# Tween Bridge Solar Farm

## 9.13 Statement of Common Ground with South Yorkshire Fire & Rescue Service

**Document Reference: 9.13**

**Revision 2**

Drawing Ref: Typical 100MW BESS Layout

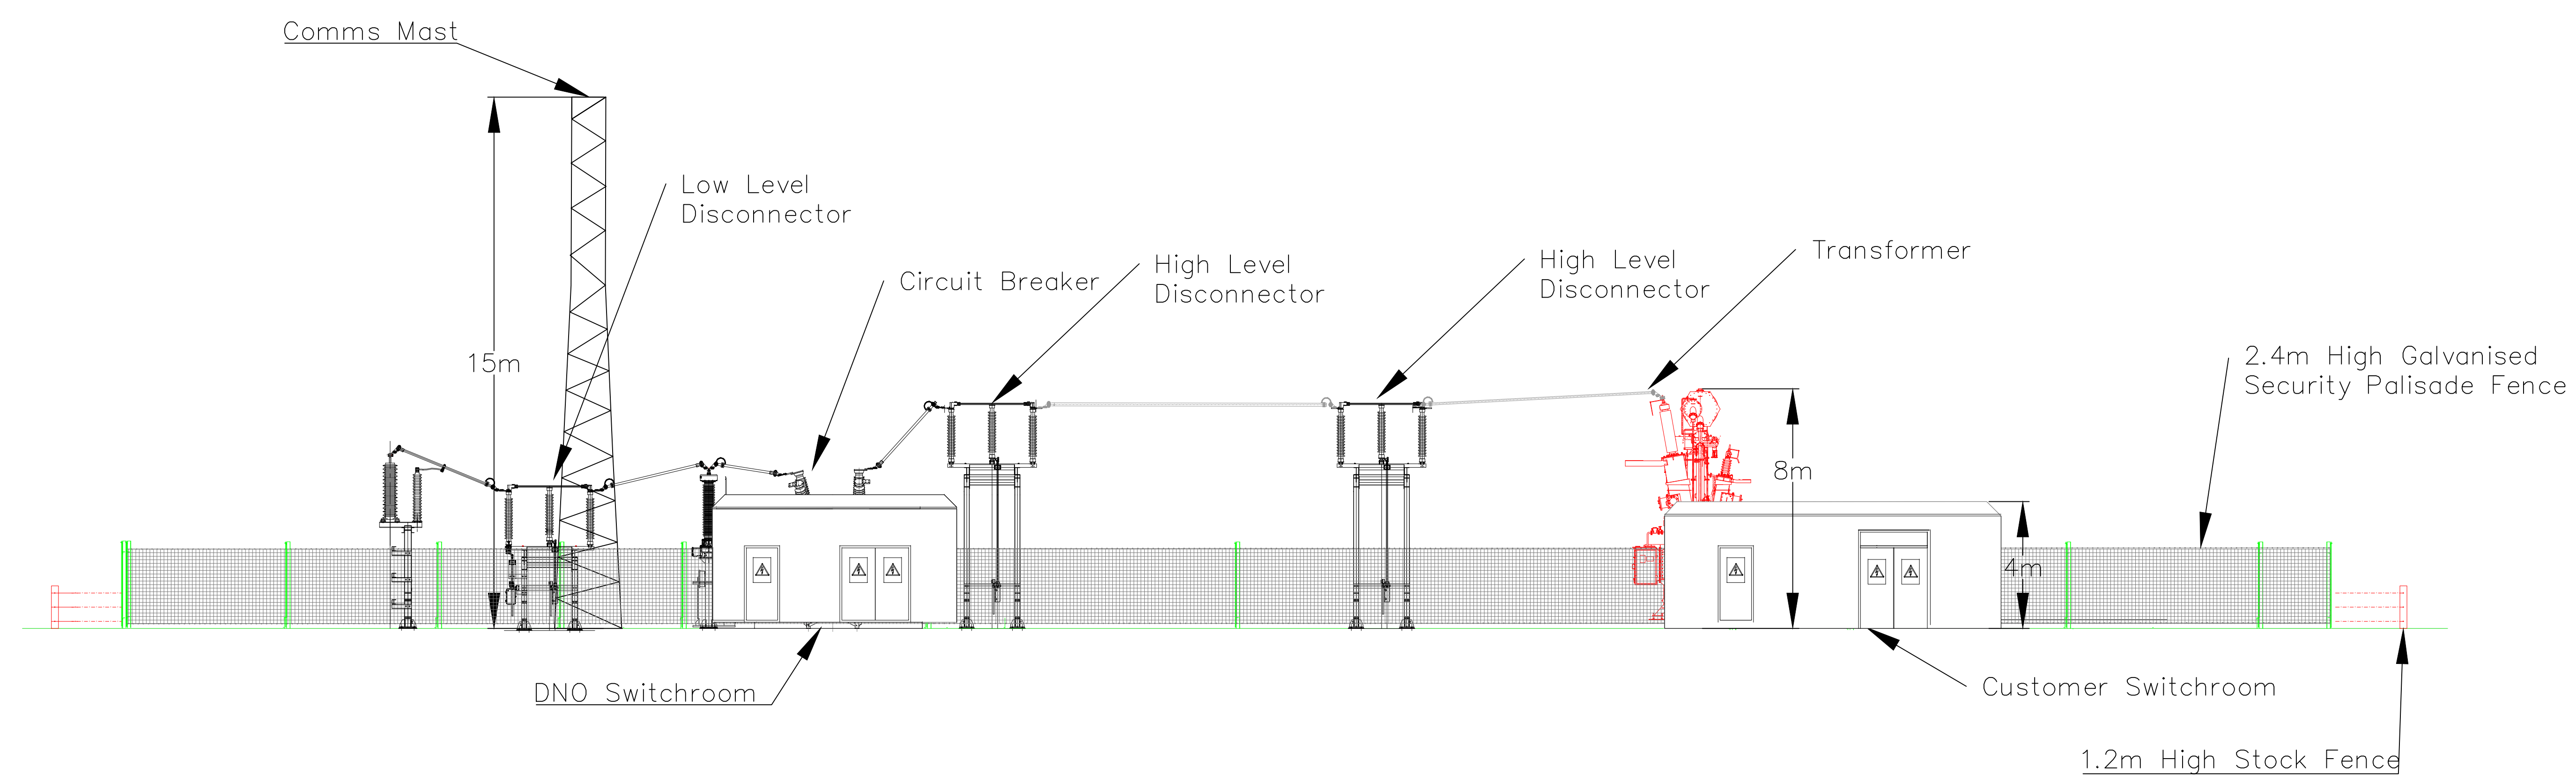
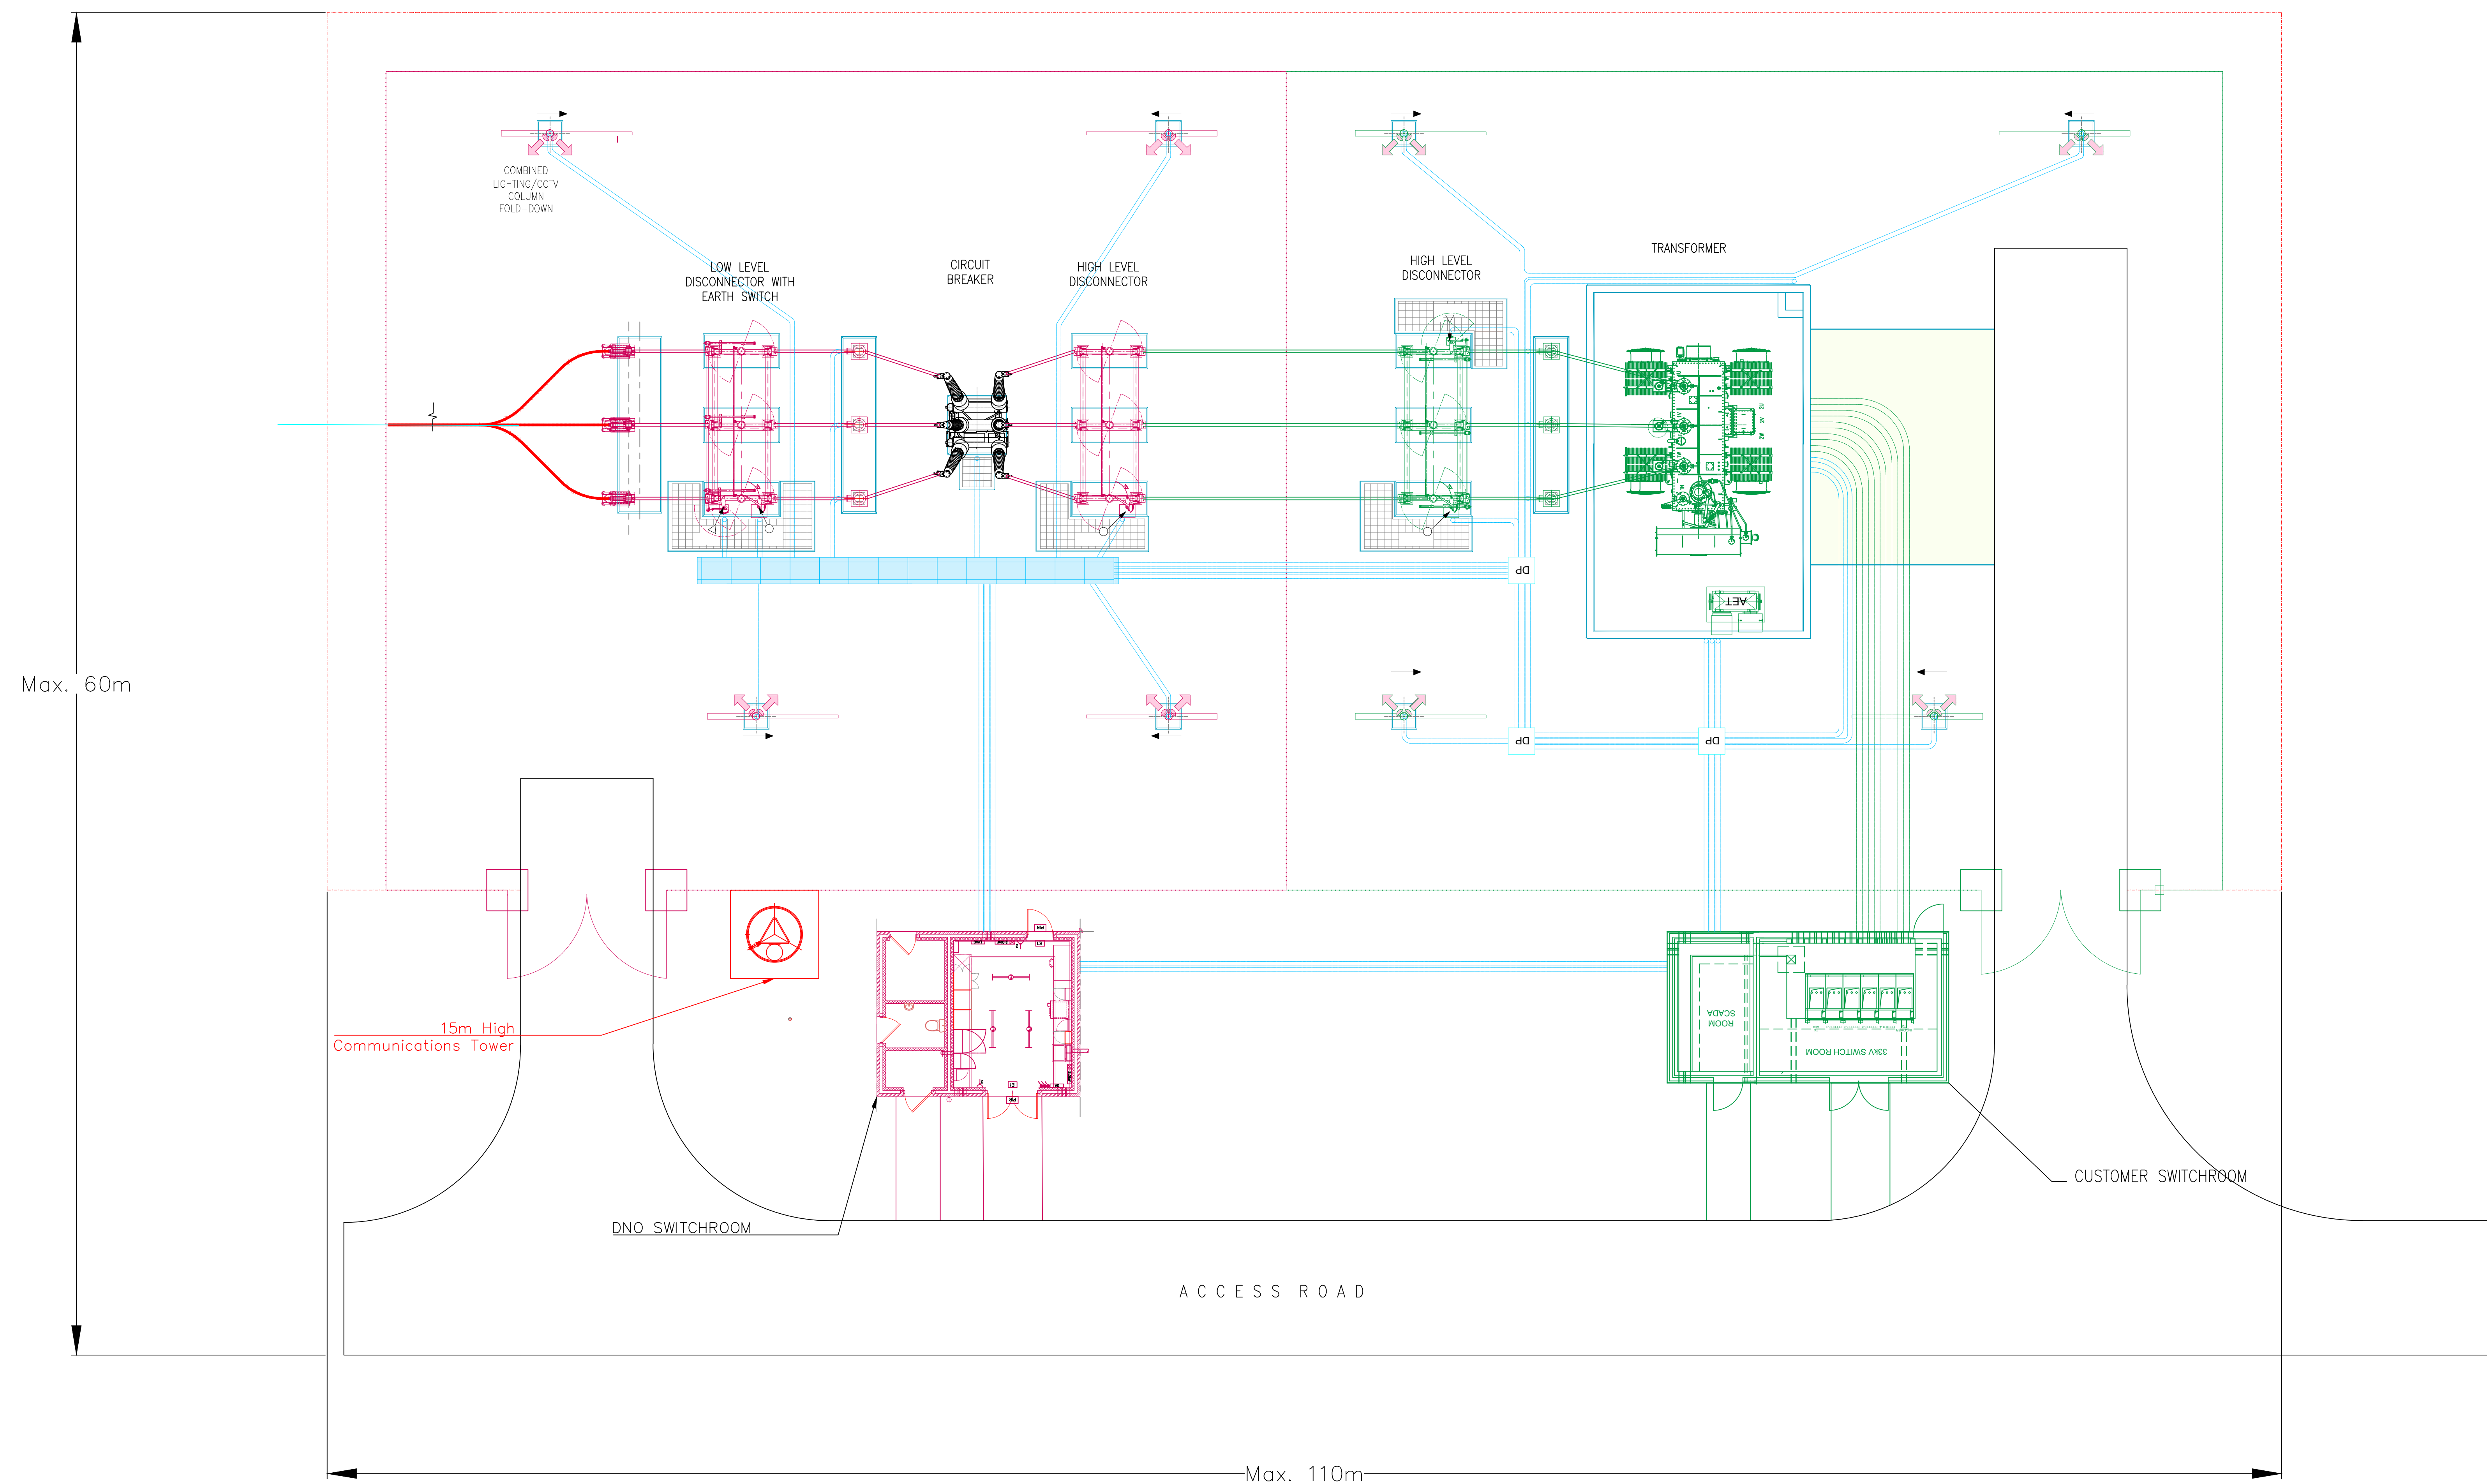
<b>Scania Rescue Pumps and Scania Turntable Ladders</b>		
SYFR 5	Water Supply	<p>In the event of a fire involving BESS, it is likely that SYFR will need to apply a higher than average volume of water to restrict fire spread. Please ensure that there is an adequate water supply within 90m to allow continuous firefighting operations to take place; please also ensure due consideration has been given to containing fire water run-off.</p>	<p>The Applicant confirms the BESS will be located within appropriate distance to adequate water supply. This is shown on the <b>Illustrative Layout and Cross Section Plan [Document Reference 2.9 Revision 2]</b>.</p>	Agreed
SYFR 6	Water Supply	<p>Separators, under the site can be introduced, to contain fire water run-off. Firefighting run-off water can have a serious impact on the environment and nearby open water. Having water separators under the site to contain this hazard means the water can be properly disposed of after the incident.</p>	<p>The outline surface water drainage strategy included in the <b>Flood Risk Assessment [REP2-O47, REP2-O49, and REP2-O51]</b> has been designed to manage potentially contaminated fire water and ensure it does not pollute the local water environment. Any fire water will be contained below ground prior to</p>	Agreed
